City of Albuquerque

July 10, 2002

RE: Lew Wallace Addition Grading and Drainage Plan (J14-D37)
Engineer's Stamp Dated July 1, 2002

SHEET
C
 105
 OF

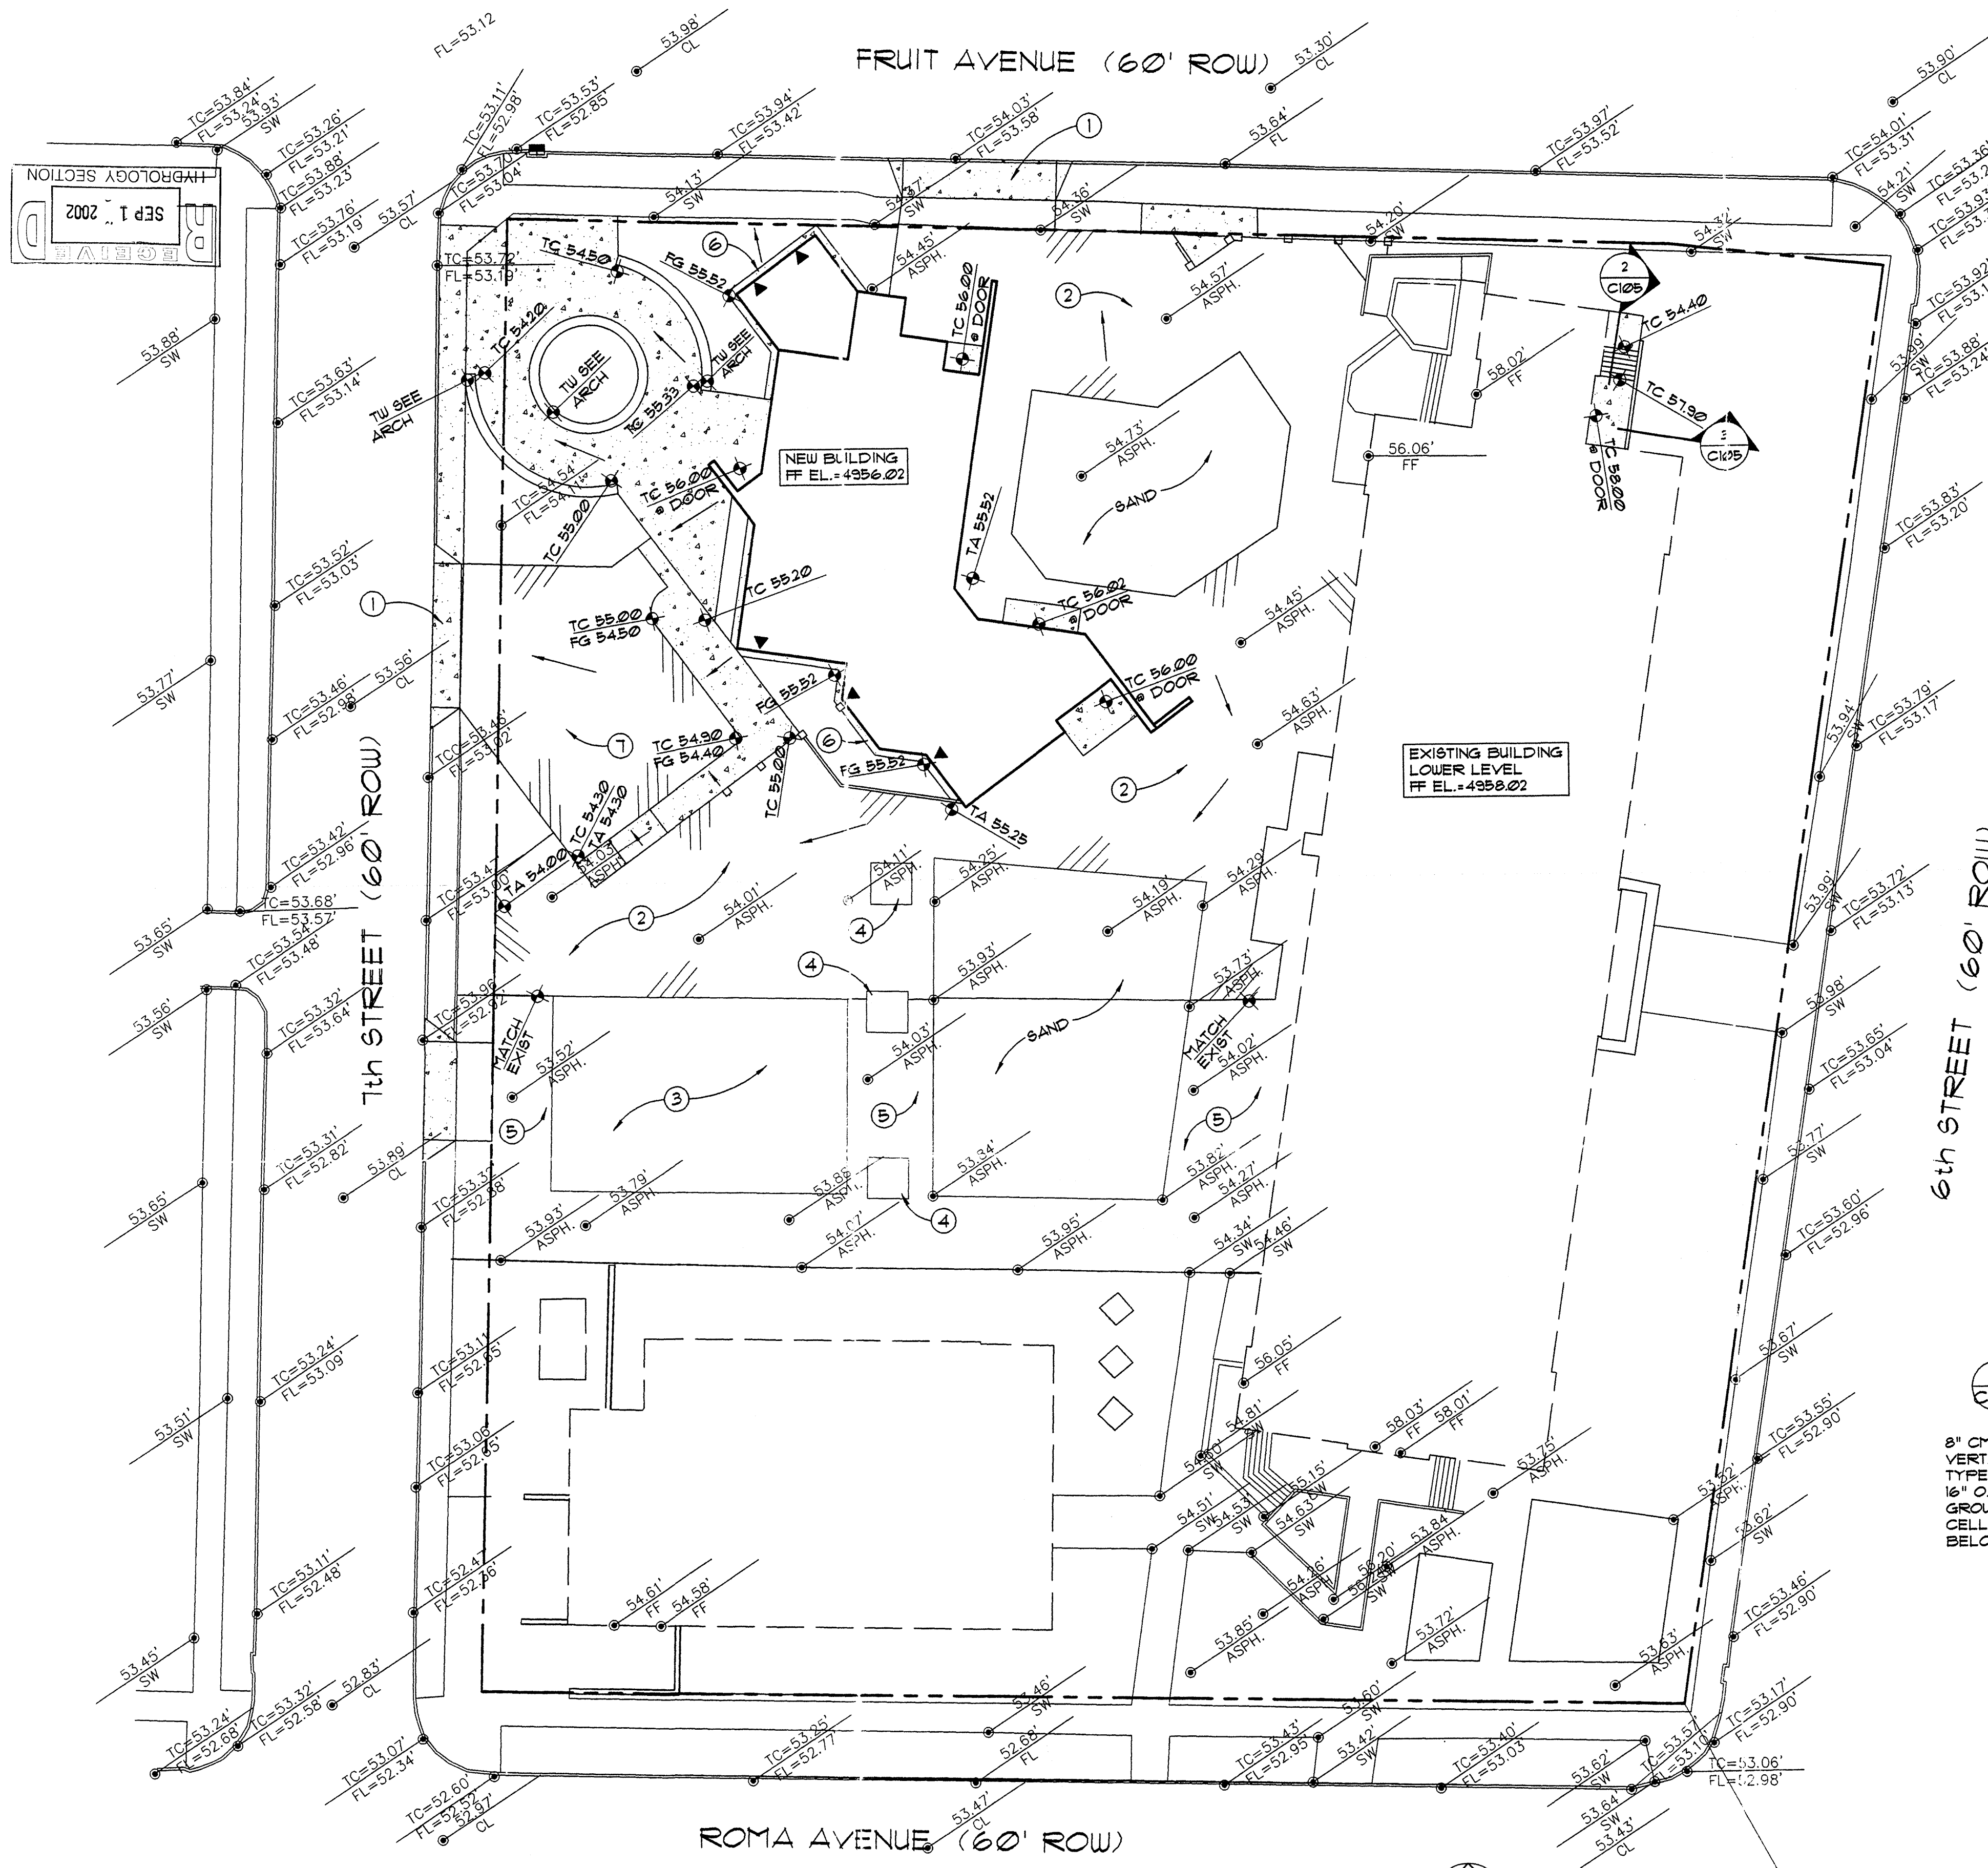
I have reviewed the above referenced grading and drainage plan received July 1, 2002 and forward the following comment regarding the northwest corner of the site: Due to the safety risk the City does not allow runoff to drain over sidewalk.
